**Re Request to Modify the Project Approval for the Scottish Hospital Seniors Living and Aged Care Facility  
Section 75W Amendment to MP10\_0016**

Approved Landscape Plan SK-09 – Showing Trees to be removed and retained in original approval

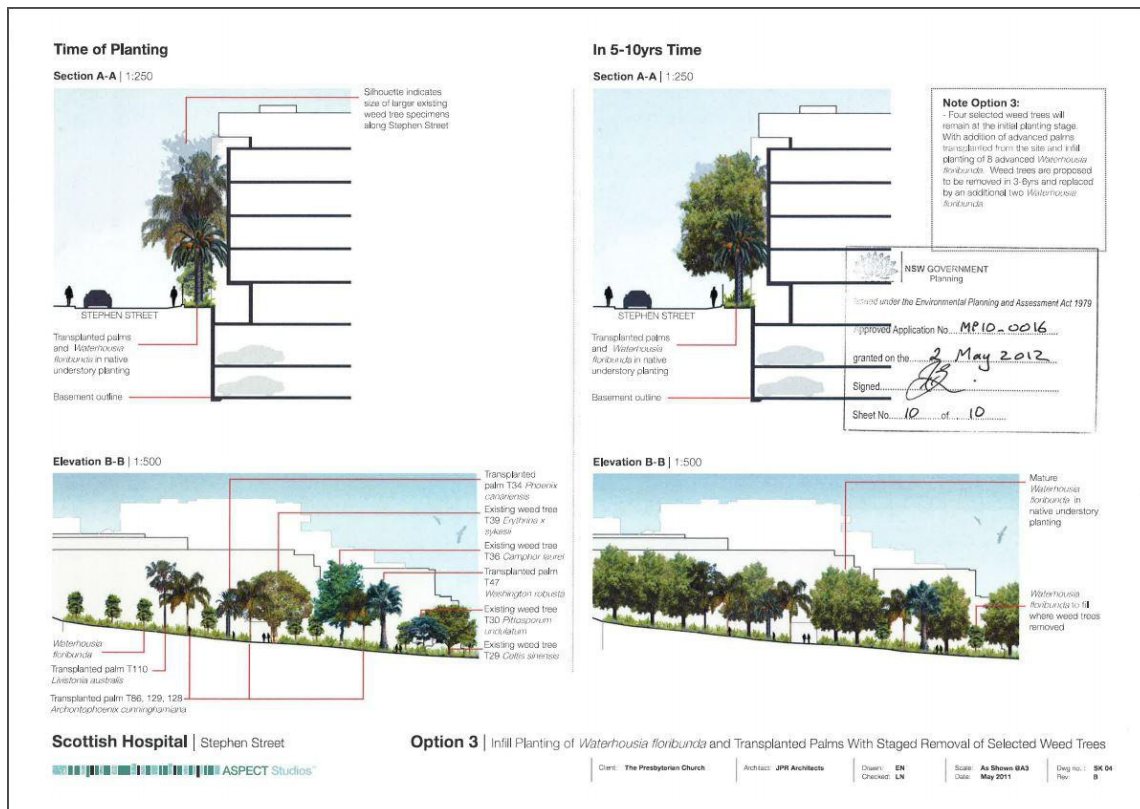
The approval called for relocation of several palms from elsewhere on the site to the Stephen St boundary to be interspersed with Weeping Lilly Pillies. Apparently this is no longer feasible due to the increase in size of the root balls since the approval, and these are to be replaced with more Weeping Lilly Pilly. There is no evidence submitted that these root balls have increased in size.

We object to the change from Lilly Pilly dispersed with palms to palms only. No sound argument has been put to support this amendment.
